Householder Proforma

2021/1466

2A Calder Avenue, Royston, Barnsley, S71 4AS

Erection of single storey rear and side extension to dwelling

SIDE ELEVATION
AS PROPOSED

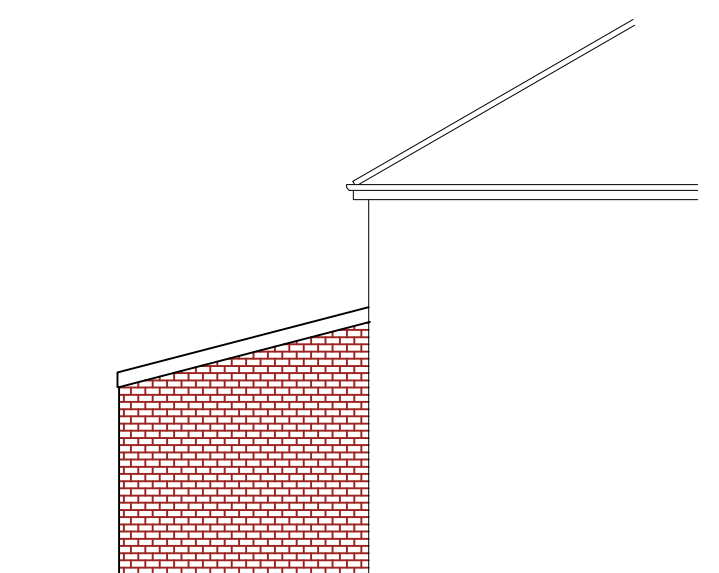
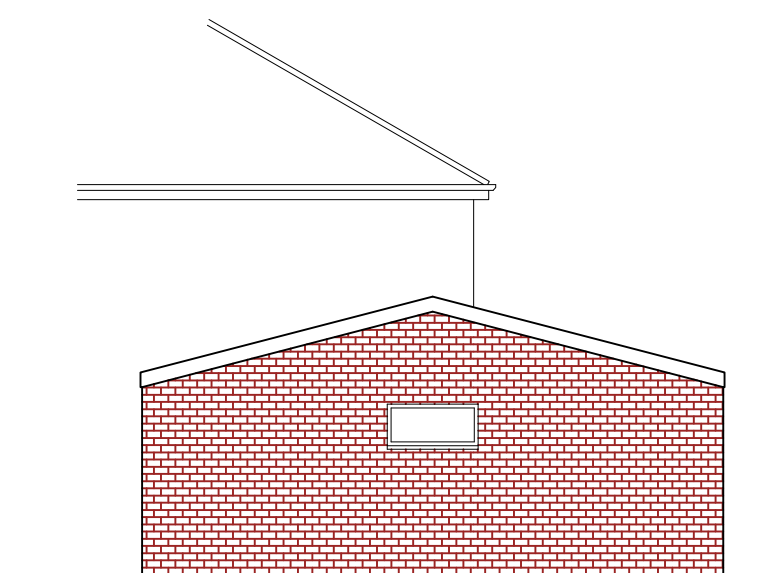
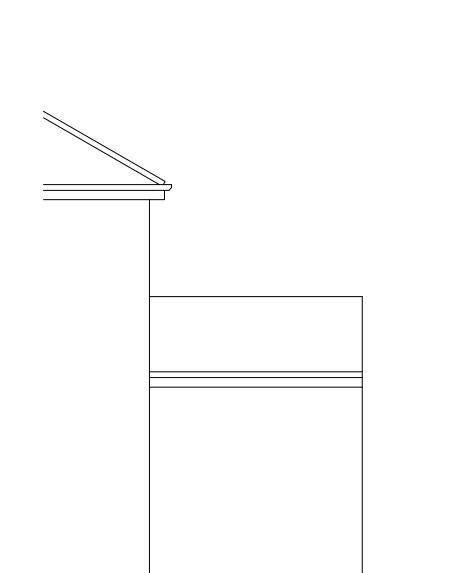
The window proposed on the side elevation of the proposed extension is located 1.6m above floor level and would not lead to a significant increase in overlooking of the property to the east. The windows on the rear elevation are located at ground floor level and the existing rear boundary treatment would provide adequate screening not to increase levels of overlooking of the properties to the rear.

GROUND FLOOR PLAN
AS PROPOSED

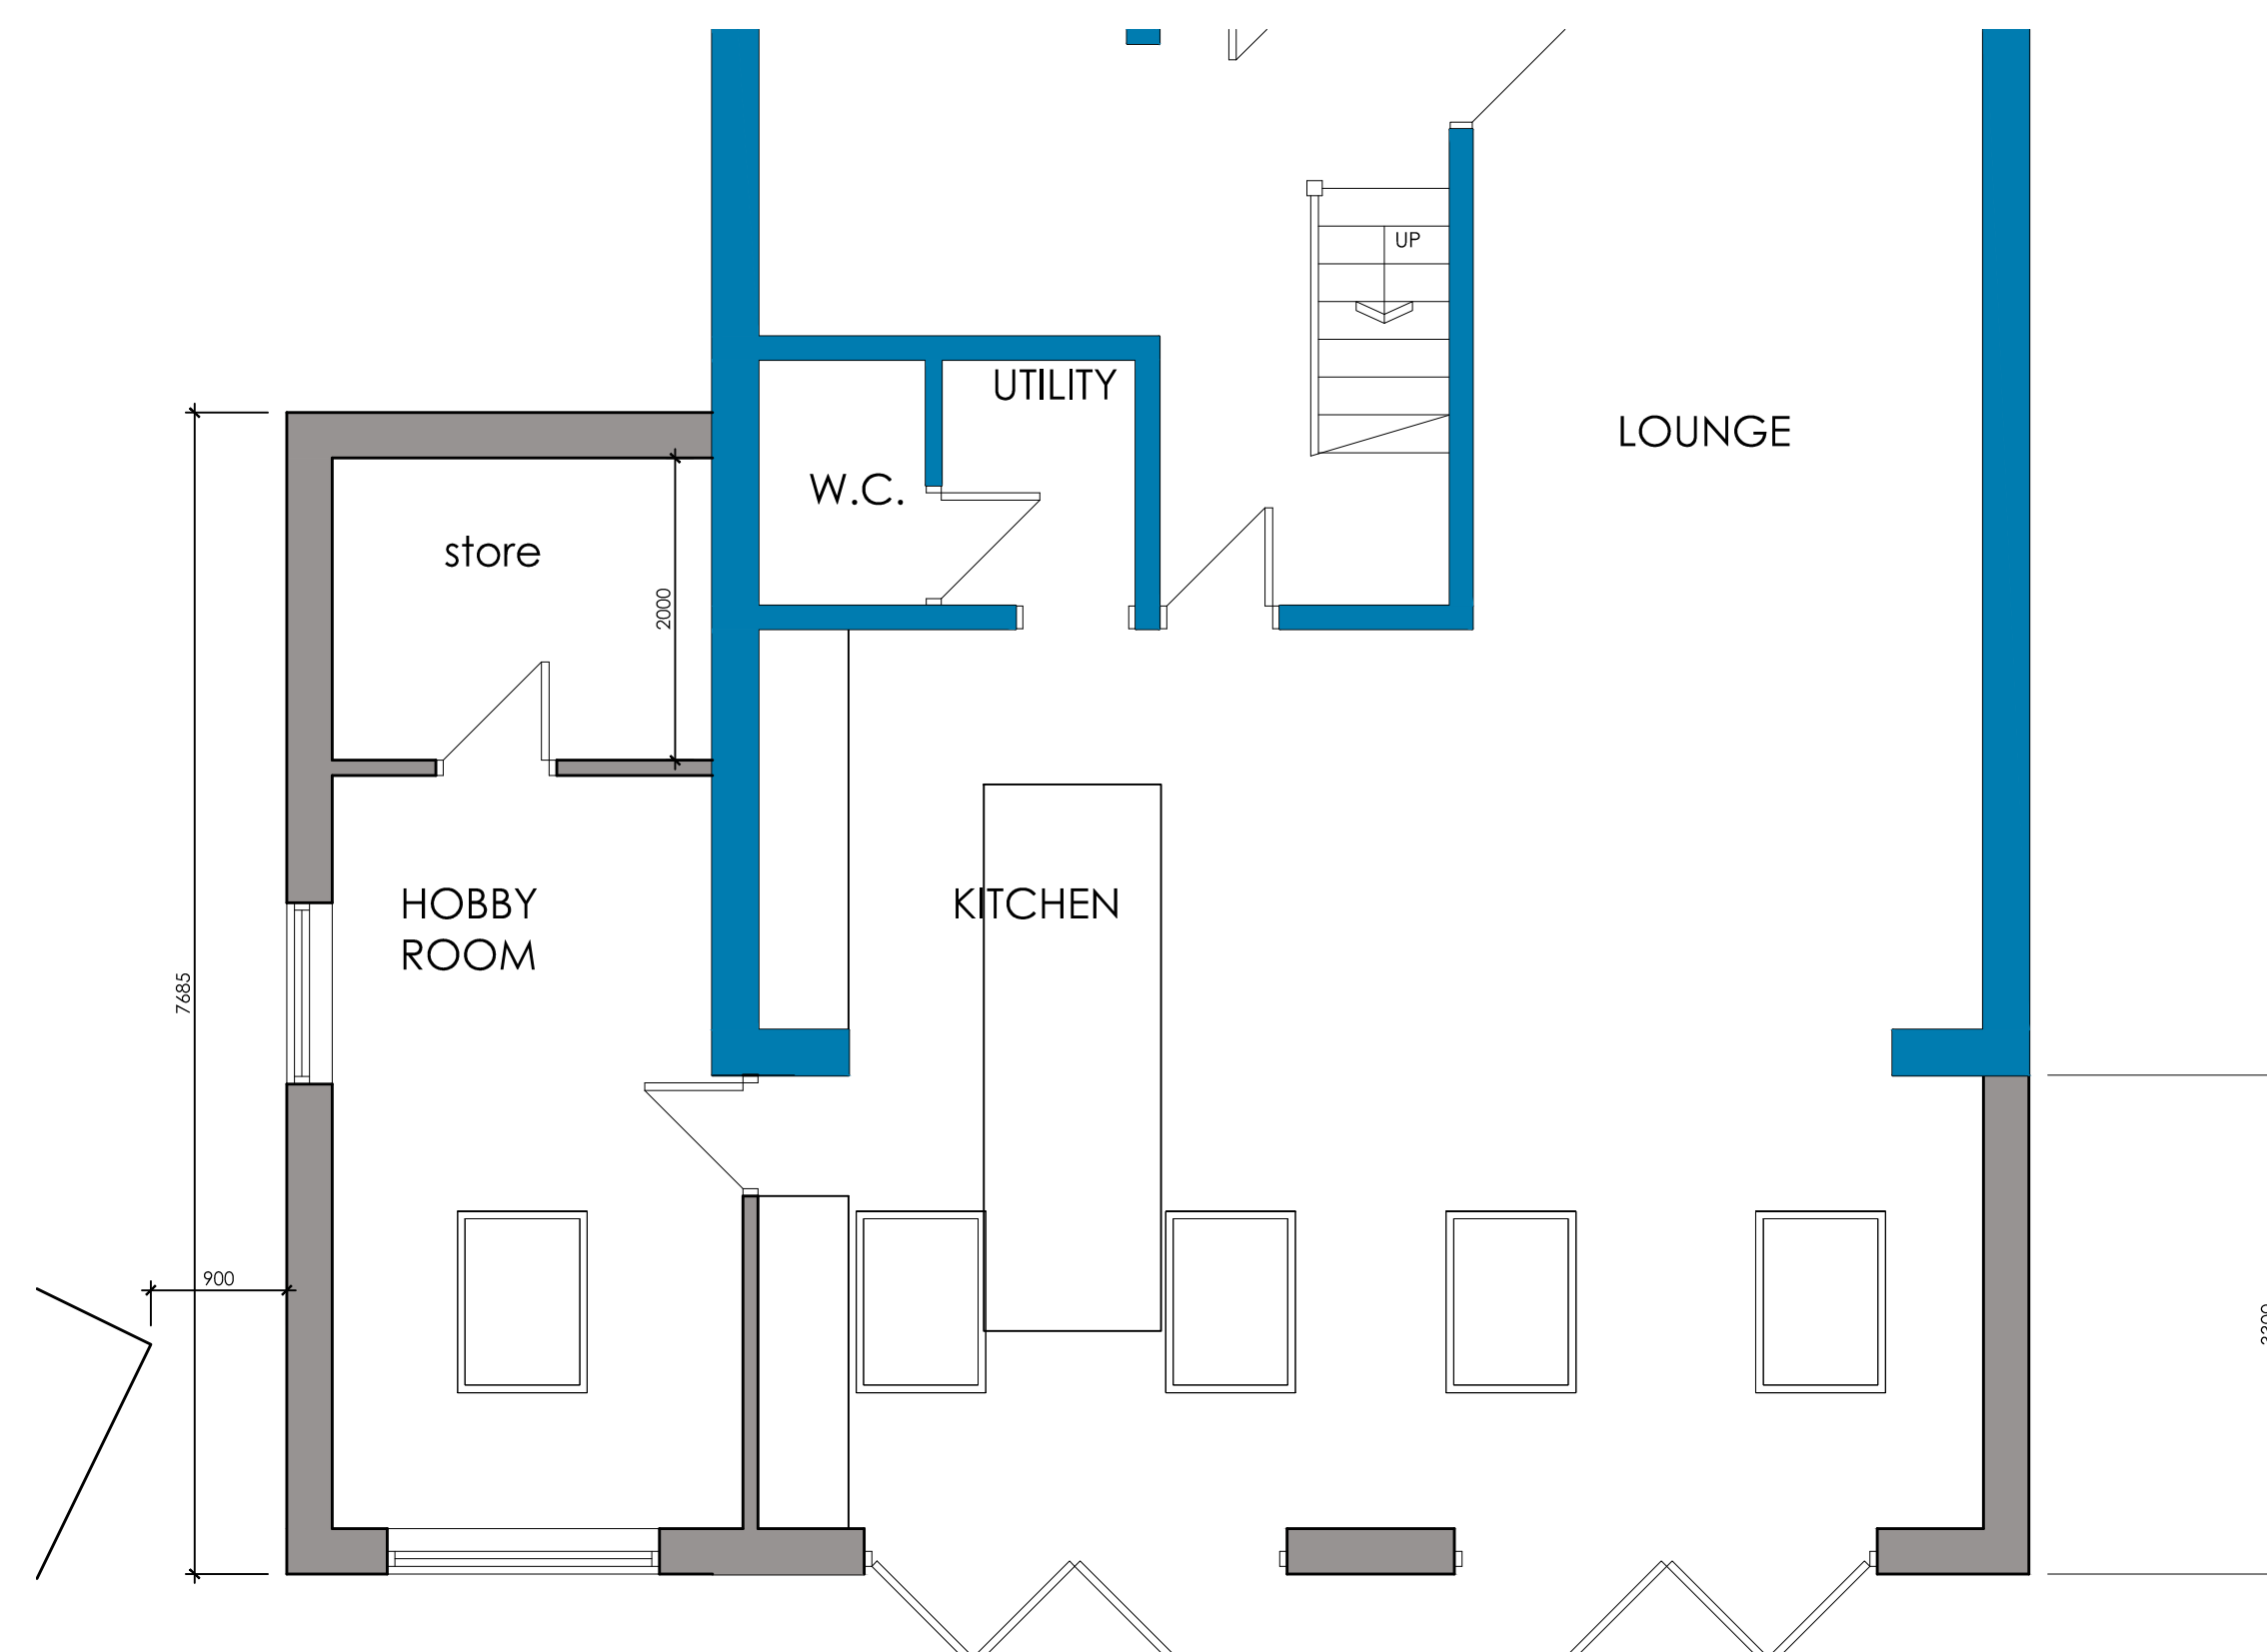
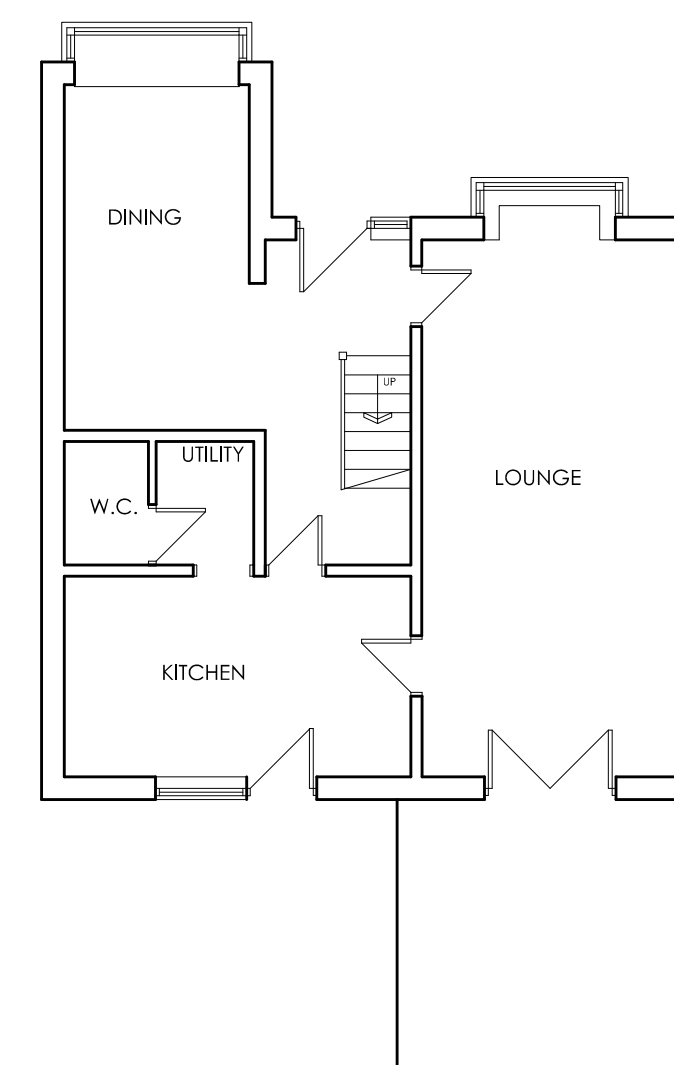
The applicant seeks permission for the erection of a single storey wrap-around side and rear extension. The proposed side extension is set back from the front elevation by approximately 4.85m, measured from the front gable projection.

The extension is to project 2.8m from the side elevation, extend the remaining depth of the dwelling (approx. 4.4m) and 3.3m beyond the rear elevation of the original dwelling.
